From: Nicola Spencer on behalf of Planning
Sent: 30 March 2021 22:06
To: Planning Scanning; Planning.Responses
Subject: FW: planning application AW/52/21/HH 59 Carlton Avenue, Po21 3EZ

From: Lisa Pilling [REDACTED]
Sent: 30 March 2021 21:11
To: Finlay Gardner <Finlay.Gardner@arun.gov.uk>; Planning <Planning@arun.gov.uk>; Christopher Clarke [REDACTED]
Subject: re: planning application AW/52/21/HH 59 Carlton Avenue, Po21 3EZ

Proposed Plans and Elevations

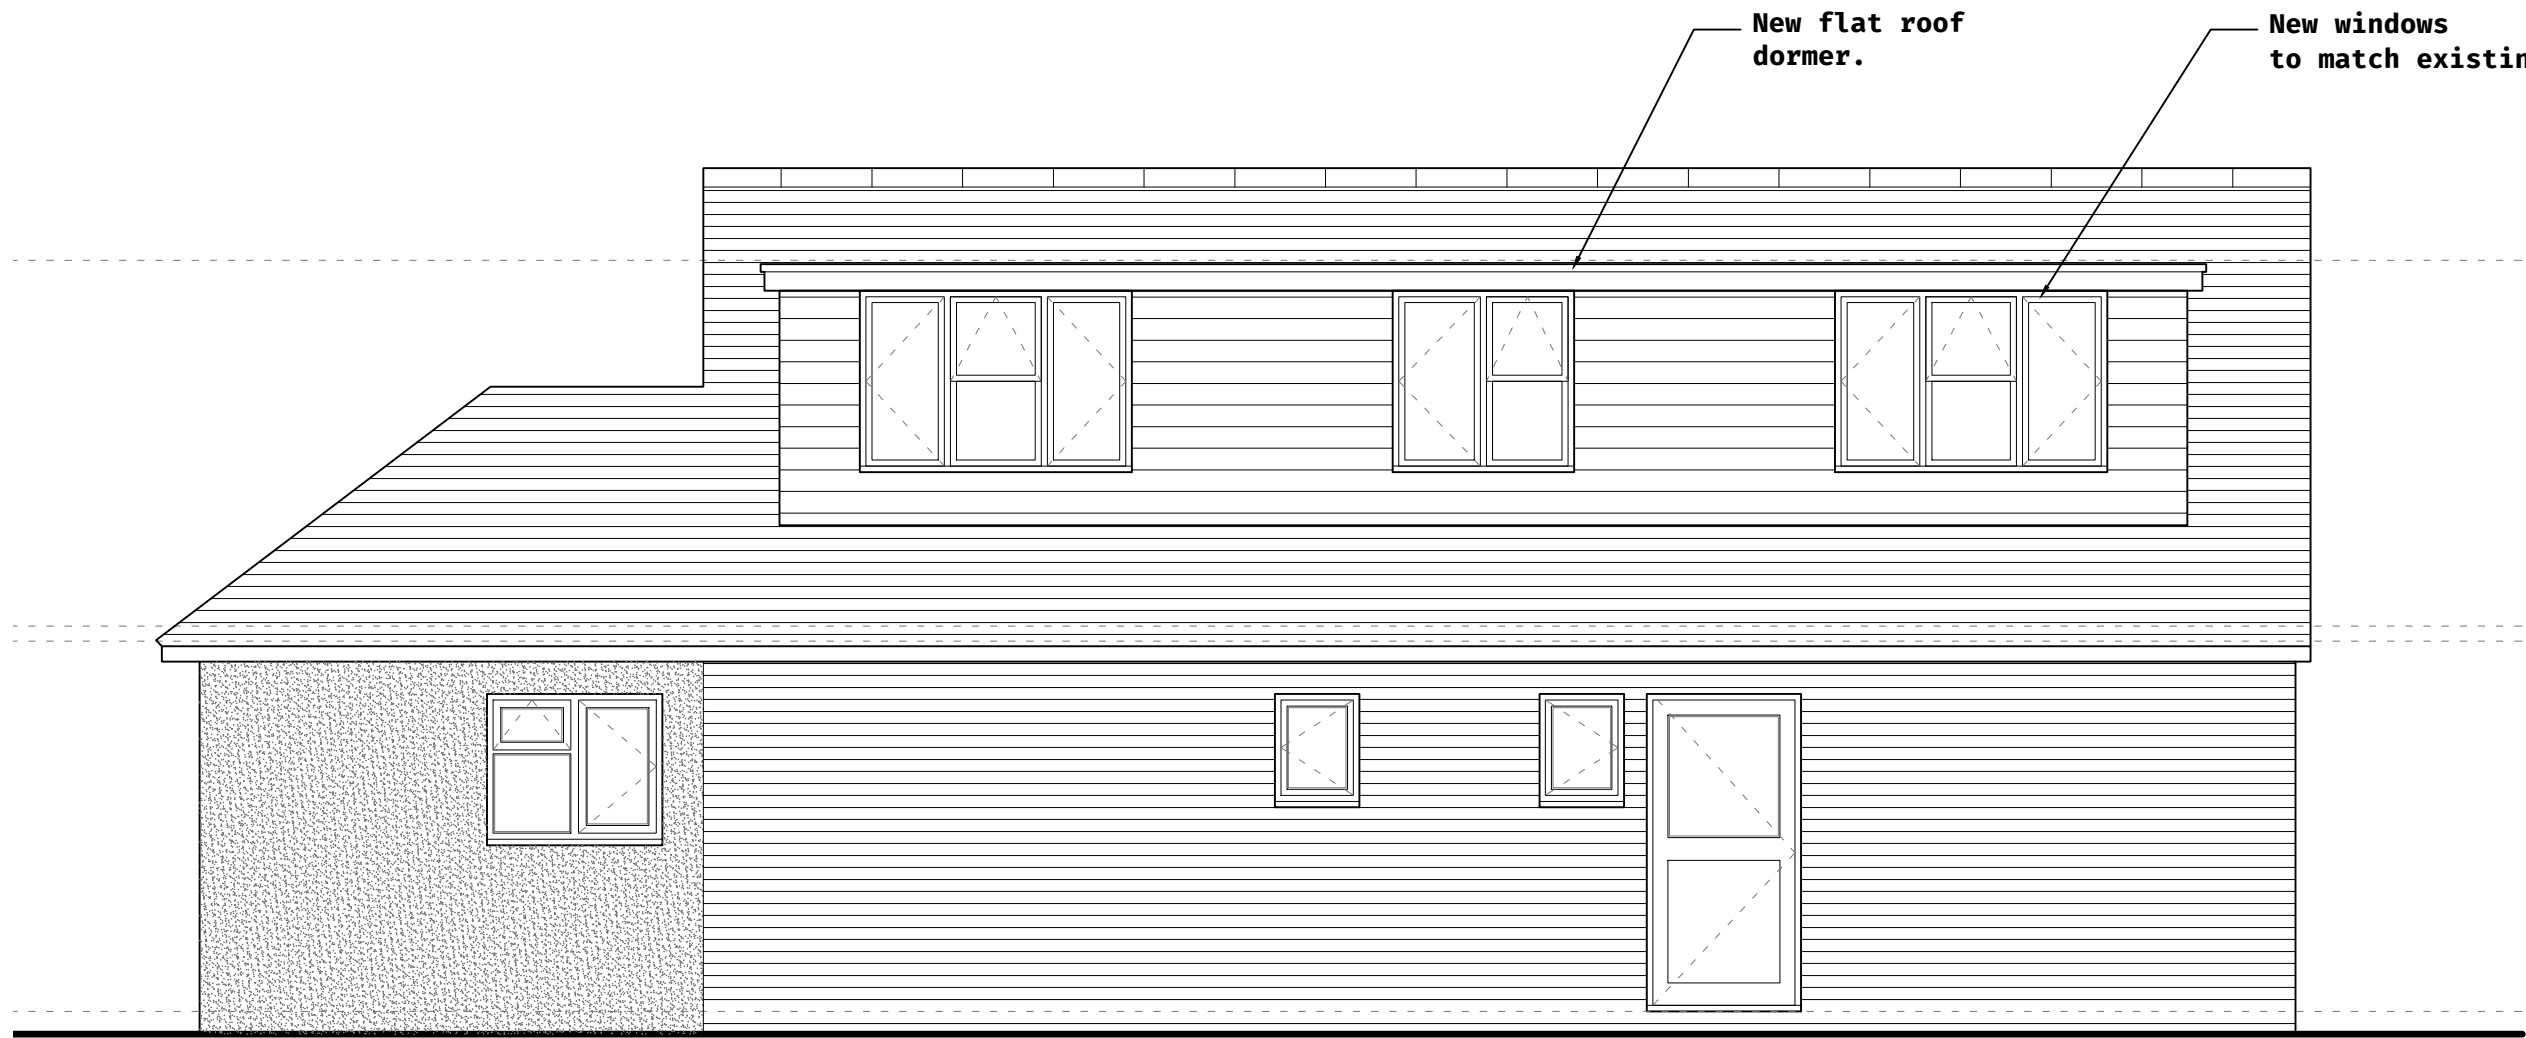
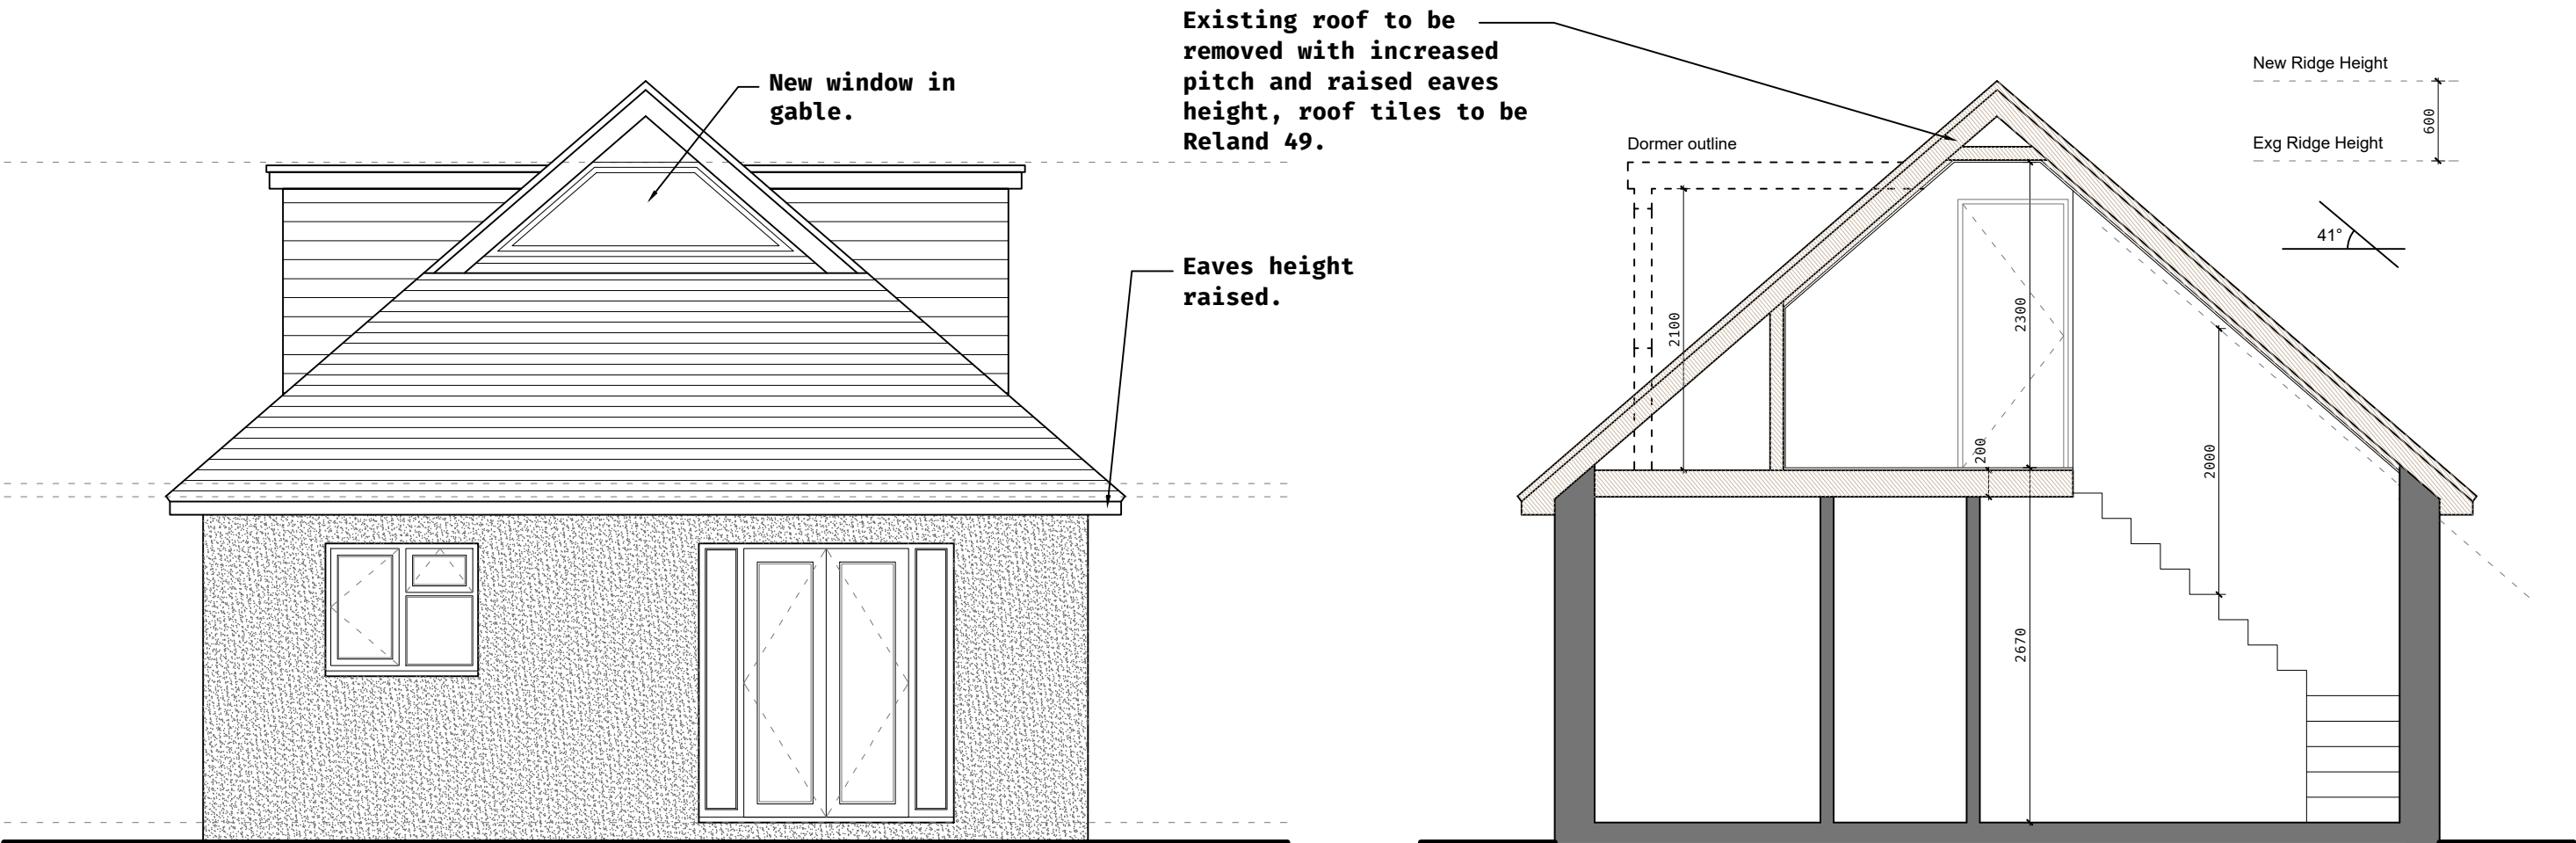
Our neighbours had informed us that they were planning to raise the roof and put dormers in, but had told us that on our side that they would be putting wardrobes. On the current plans, there are 2 dormers and a velux on our side which would give them direct views into our garden, patio and also into our newly extended lounge. We are very concerned that we would lose all privacy.

We request that the plan is reviewed in light of this.
